CITY OF ALBUQUERQUE

November 9, 2017

**Re: Cielito Lindo
5109 Central NW
30-Day Temporary Certificate of Occupancy- Transportation Development
Transportation Development Final Inspection**
Engineer's/Architect's Stamp dated 12-05-16 (K11-D085)
Certification dated 10-03-17

A1.2

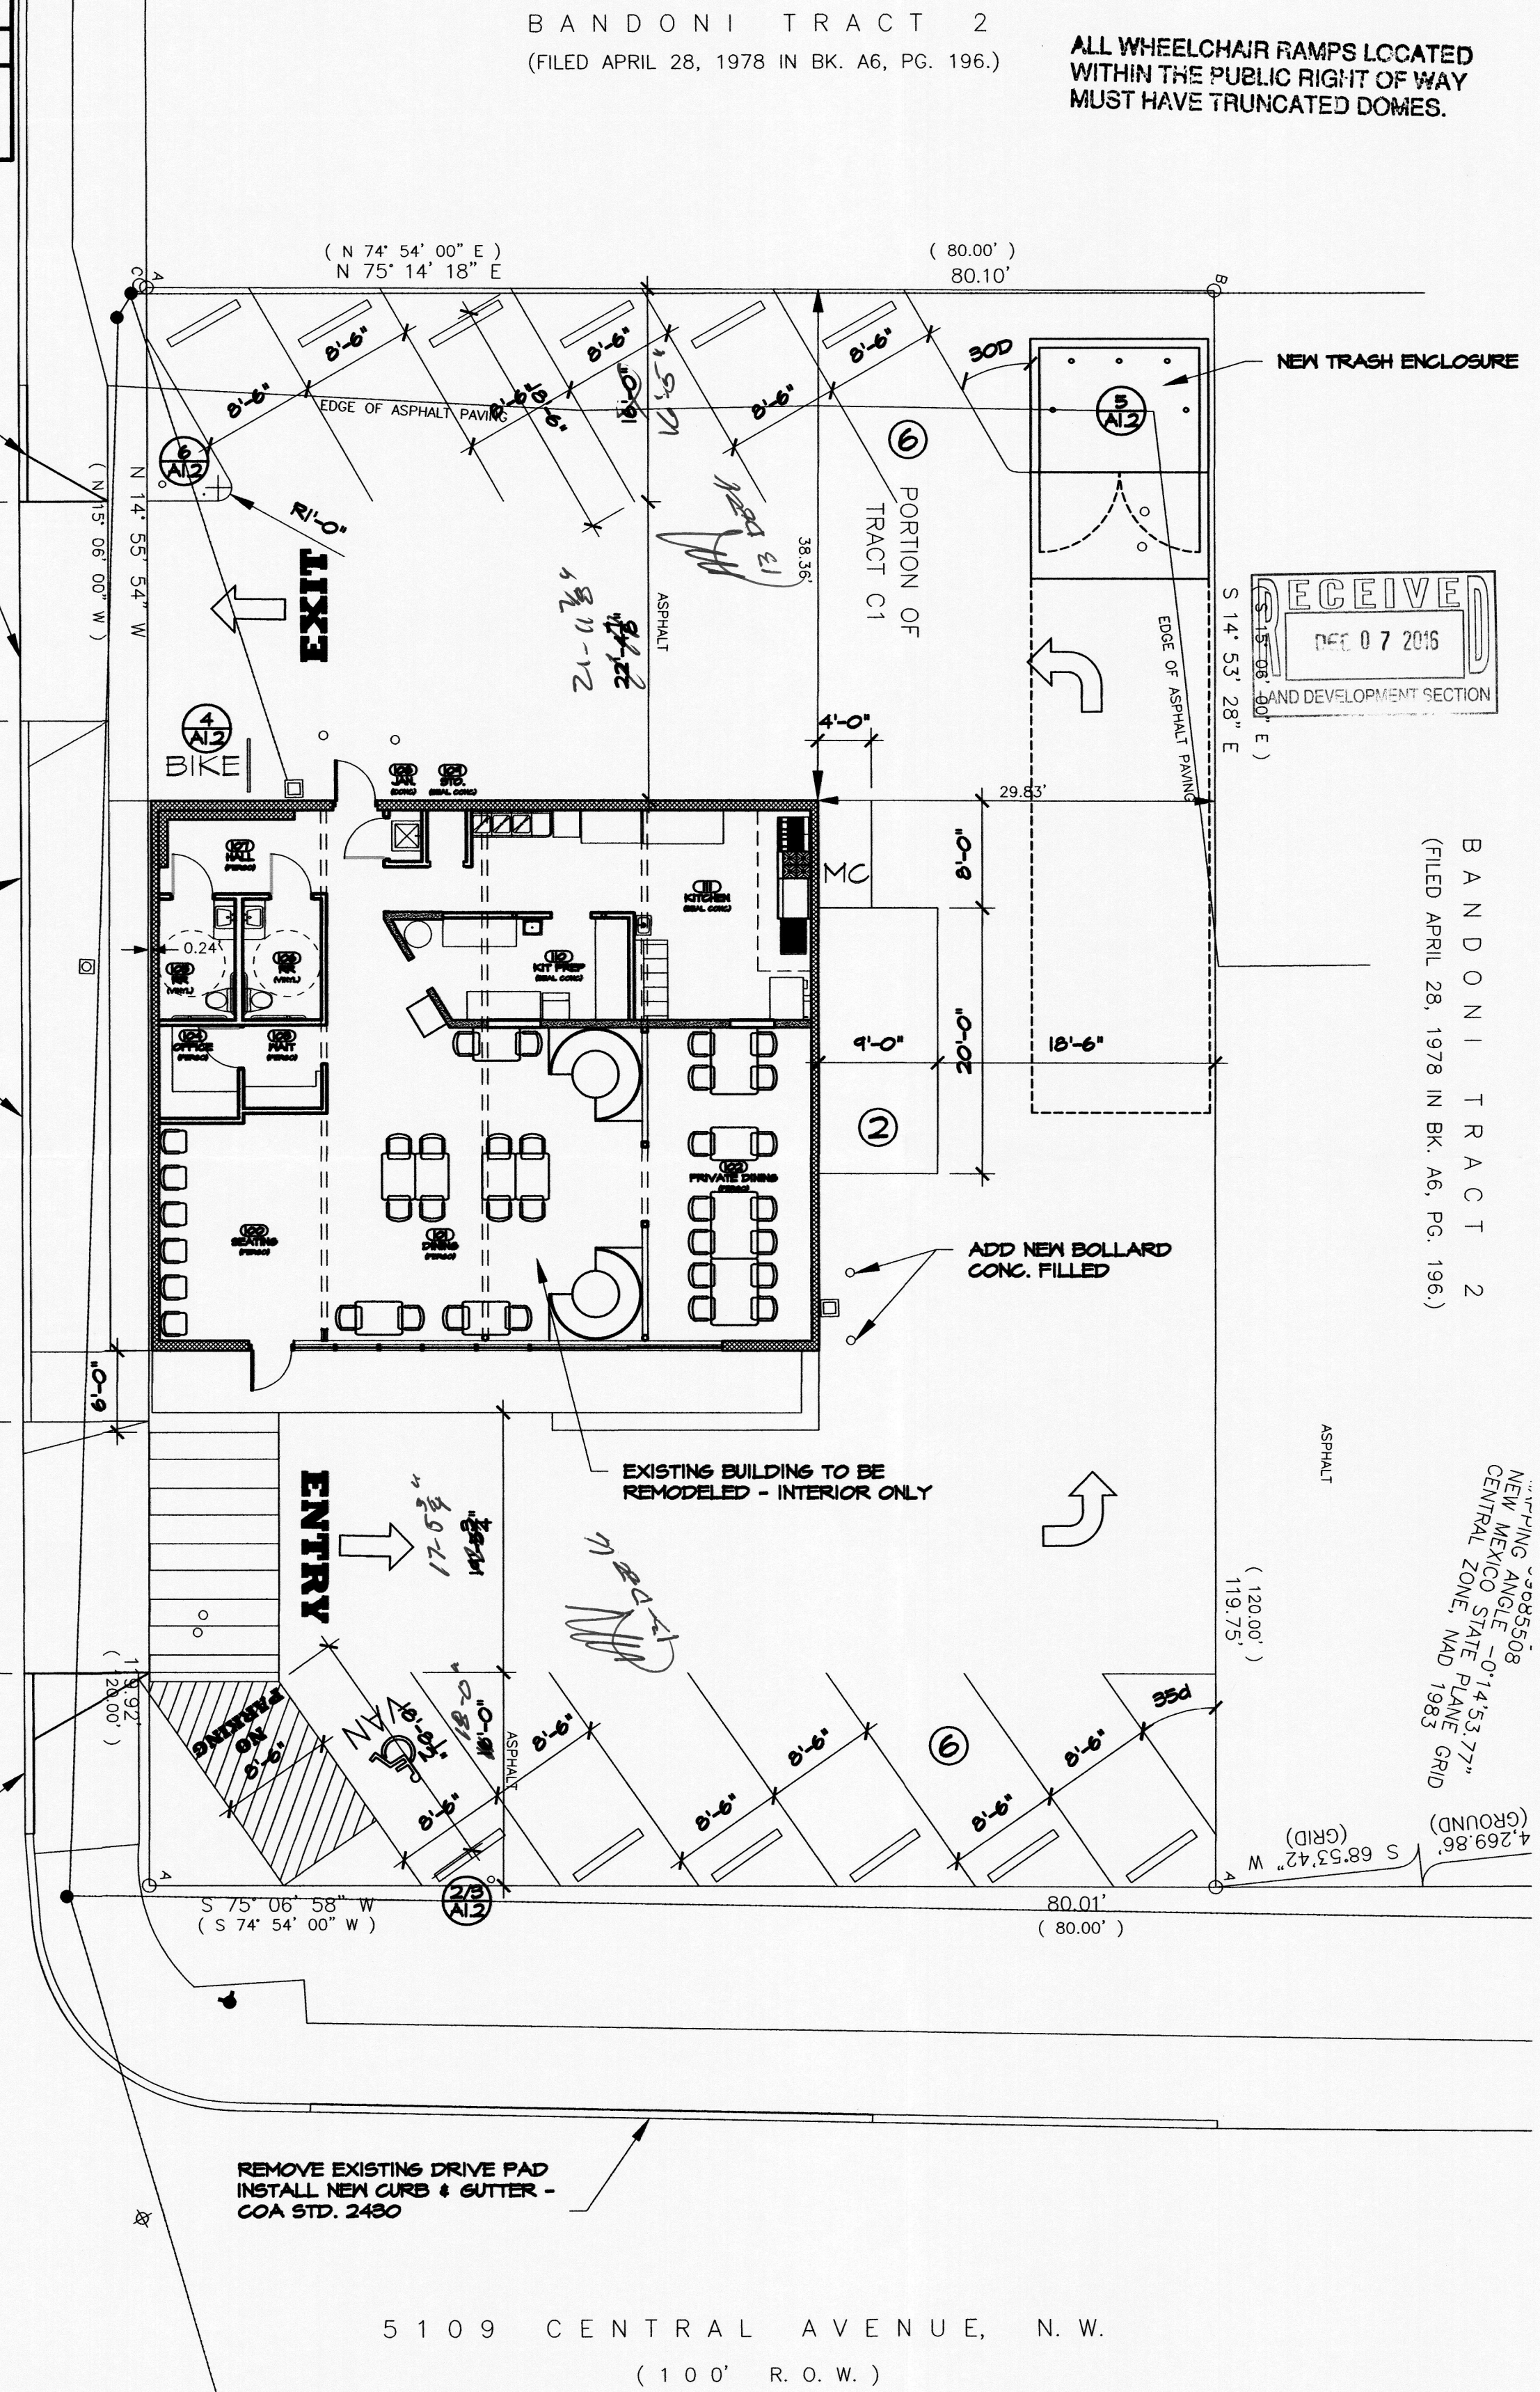
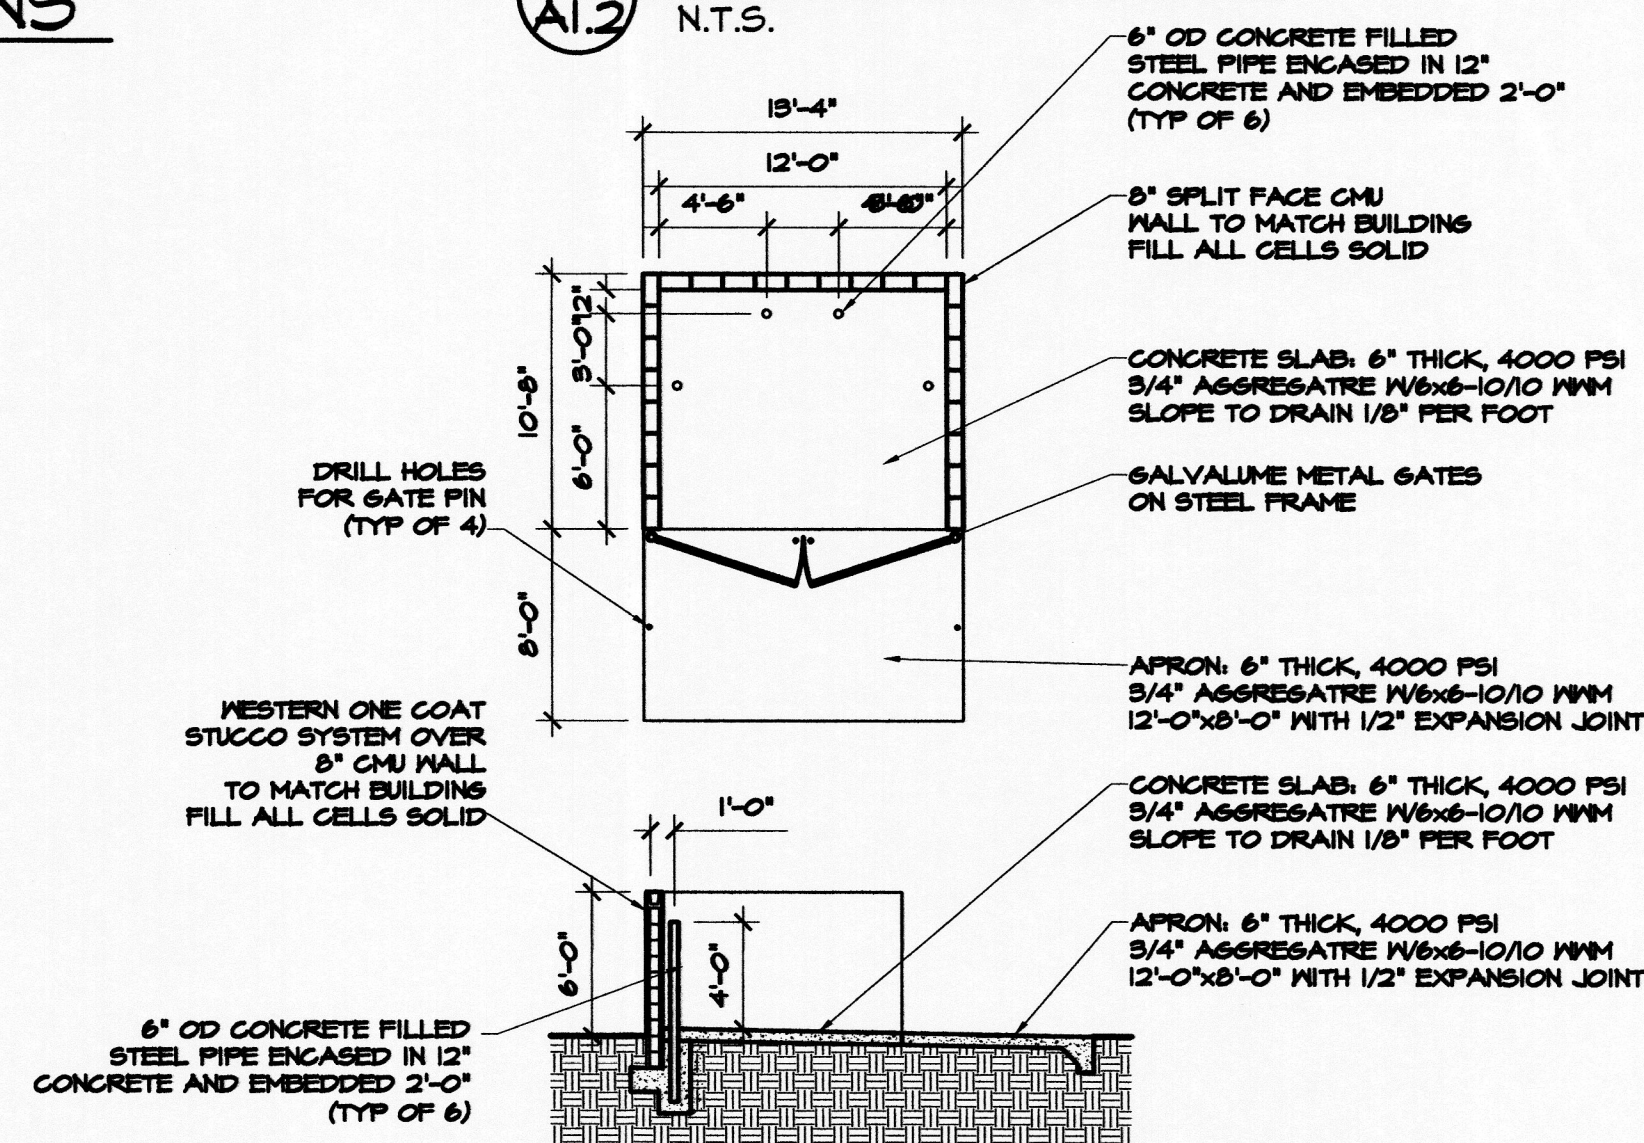
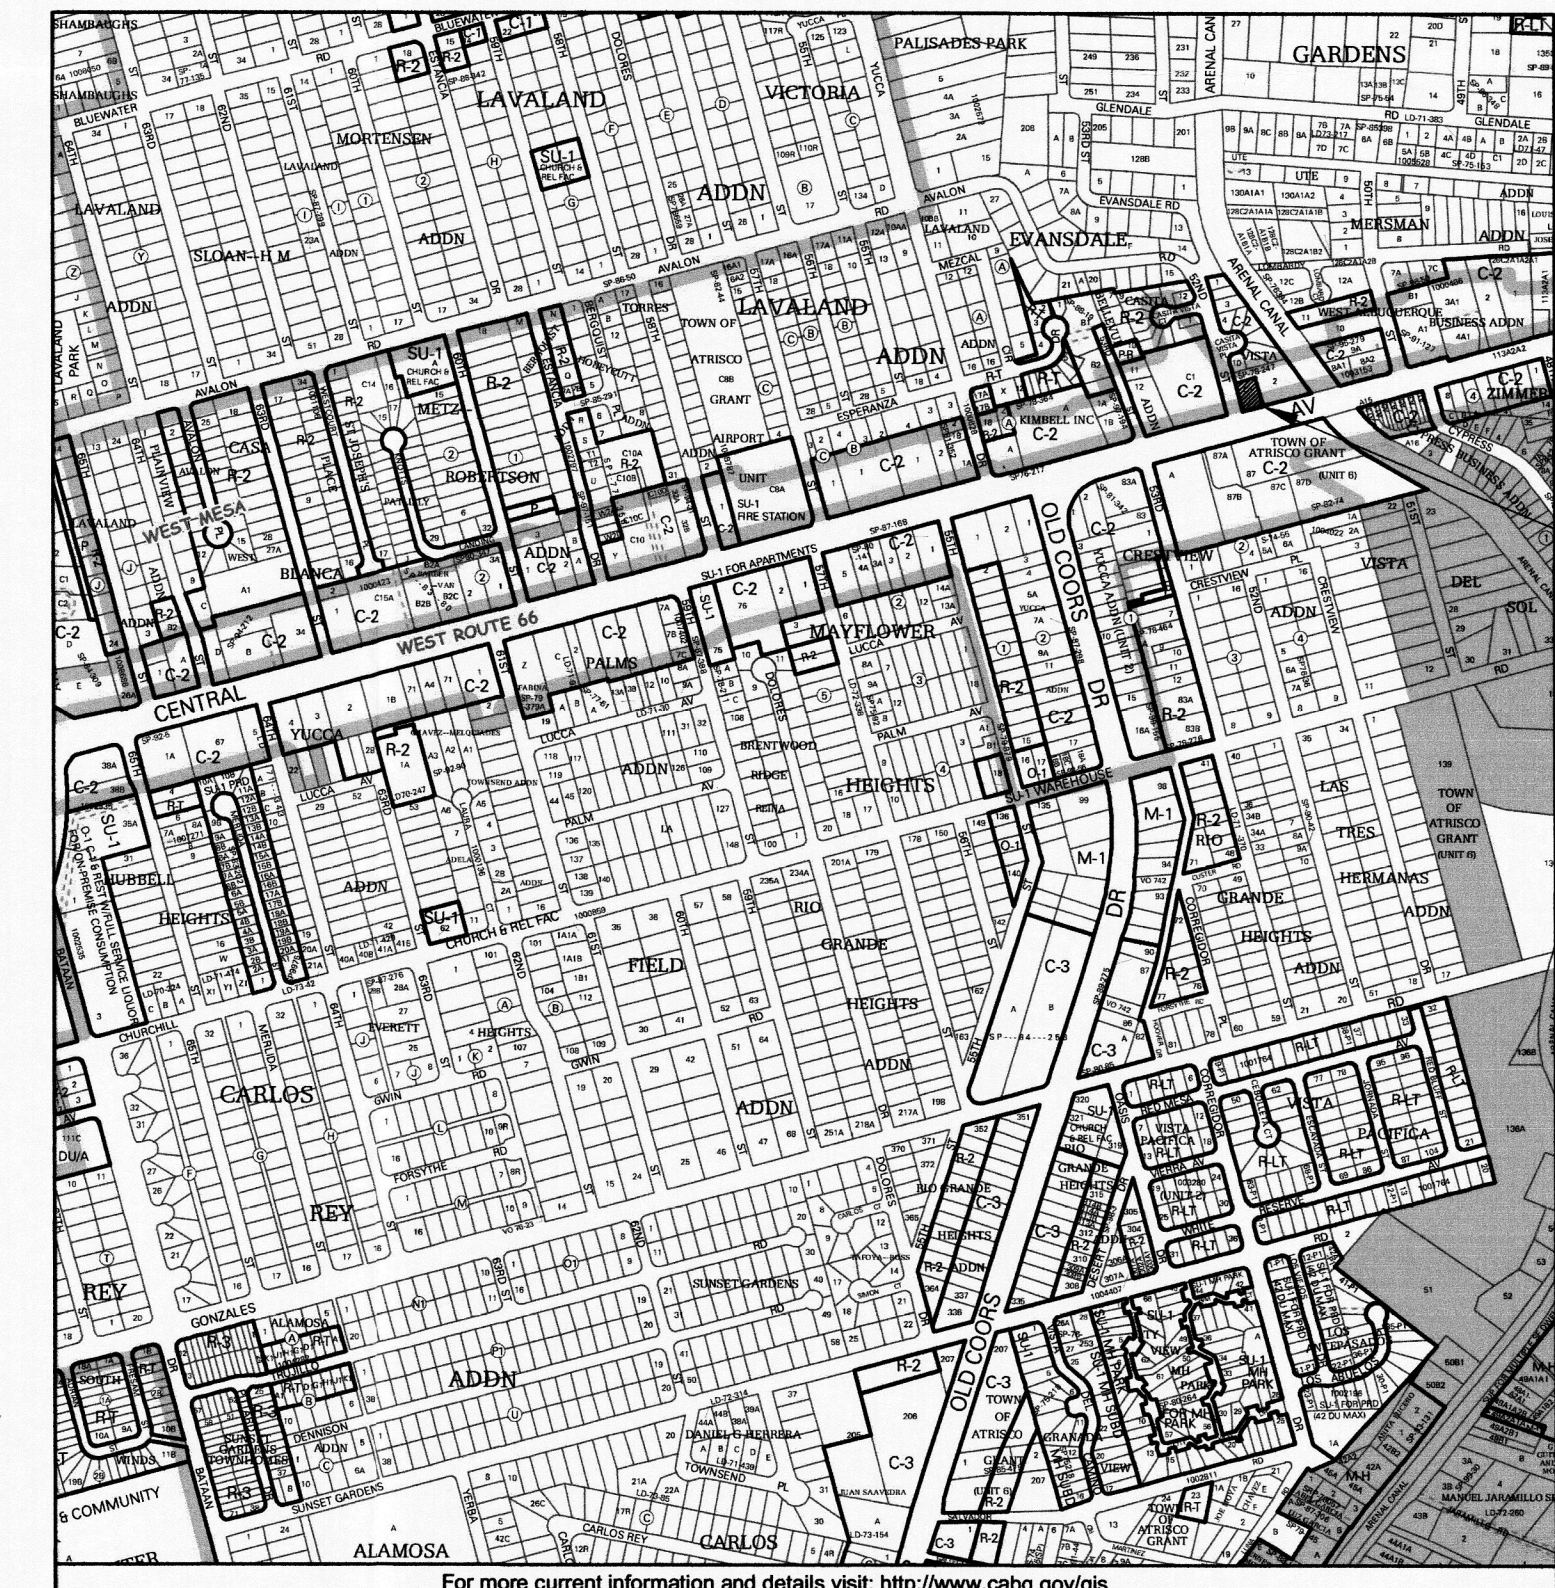
1. Per the zoning code, a 6 ft. wide ADA accessible pedestrian pathway is required from the public sidewalk to the building entrances. Please clearly show this pathway and provide details.

2. The parking spaces to the north of the site must be striped to 18 feet in length.
